Planning app. no.3/2022/0105

Response to RETROSPECTIVE planning application 3/2022/0105.

Drawing: **Planning Consent**

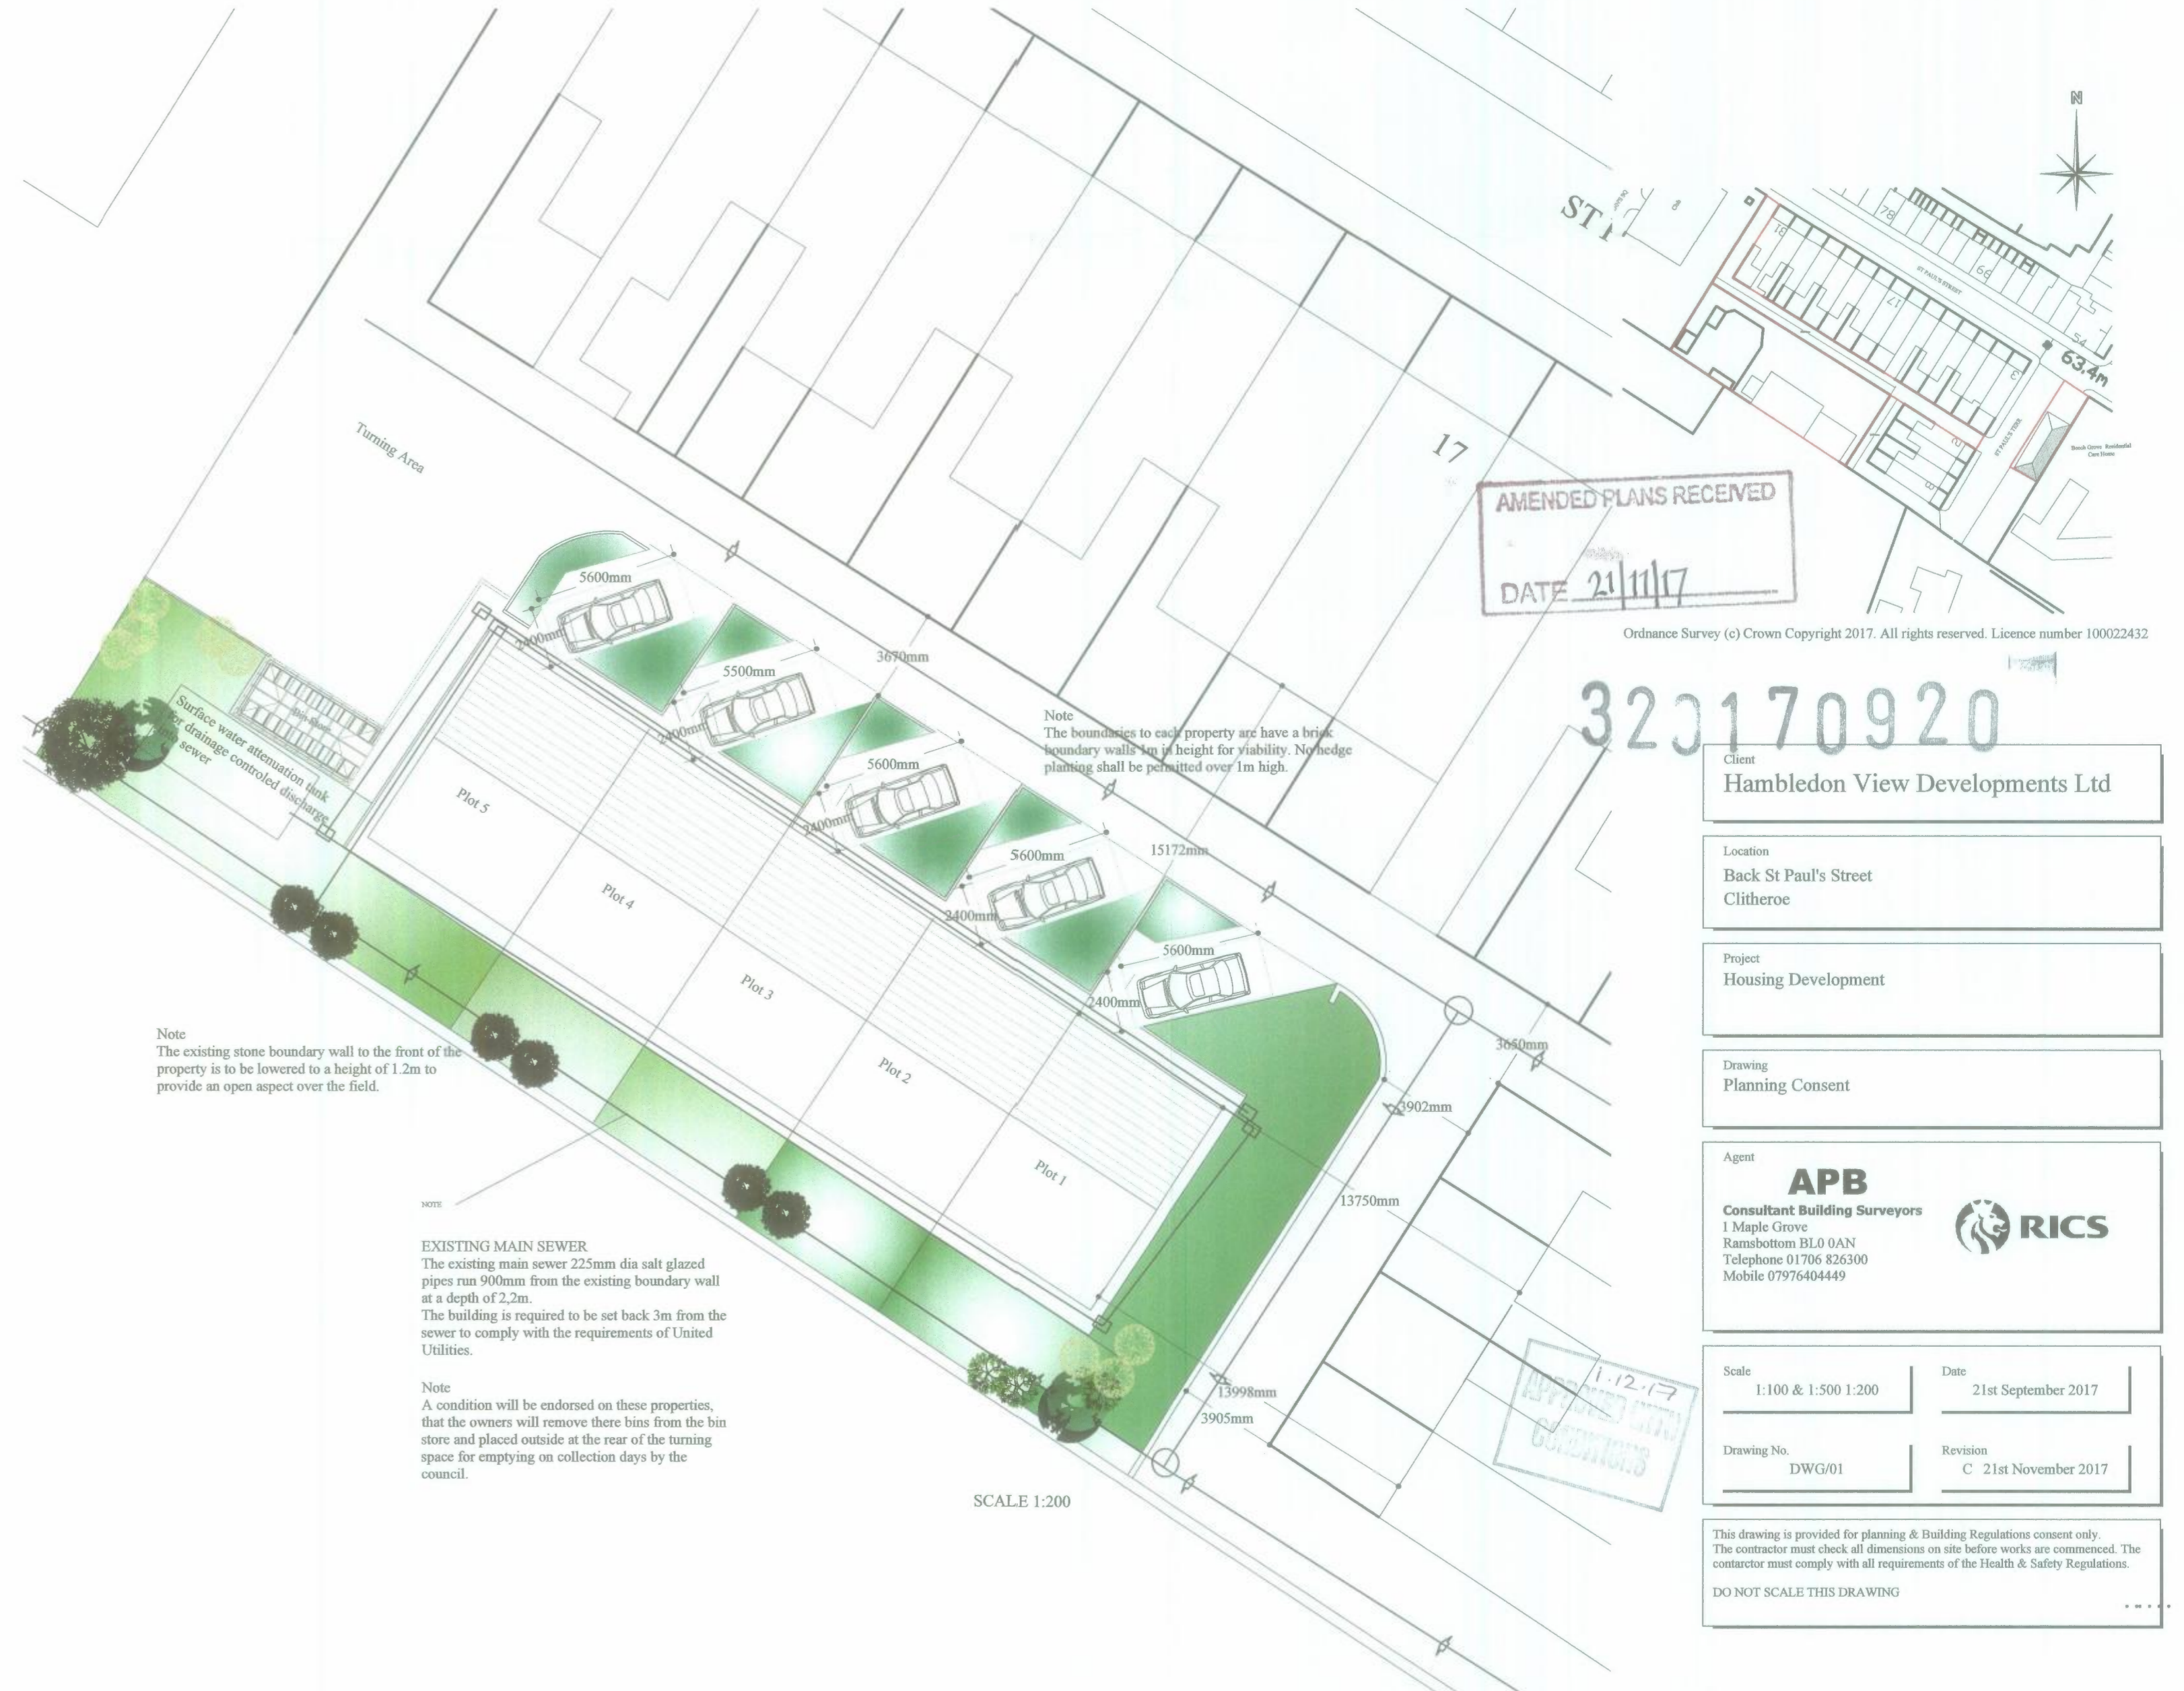
1. Please refer to planning app.3/2015/0312 highway response from [REDACTED] (highway development) which highlights the need for the turning head.
2. The safety of all vulnerable road users, pedestrians, children going to Roefield and the play area, dog walkers and the elderly will be at more risk of injury from an increase in reverse maneuvers, especially without a pavement and no street lighting in the darker hours.

5. Please refer to planning app.3/2017/0920 Highway response from [REDACTED] [REDACTED] which recommends the turning head should be made larger and the need for a bin store should be on site.

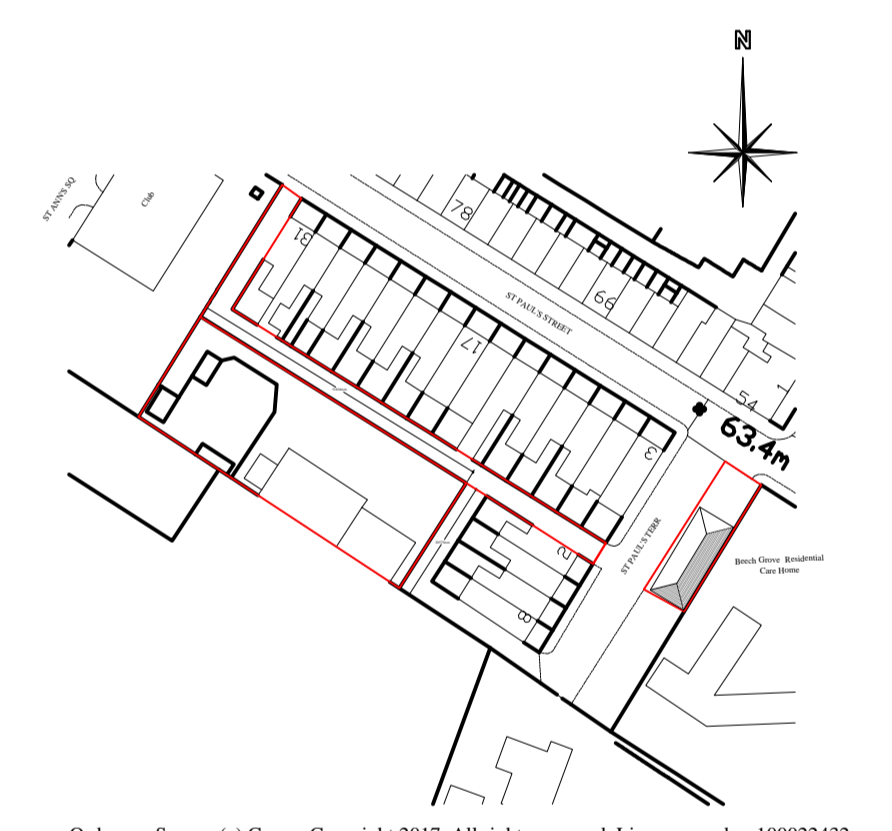
6. The small turning area that has been put in for cars to turn round instead of the original area is not adequate for large vehicles. Also they have erected a wooden fence around this small turning area which is nearly 2 meters high instead of 1meter.

I hope that you insist that the original plan for the turning circle is followed to the letter and safety is paramount to your decision.
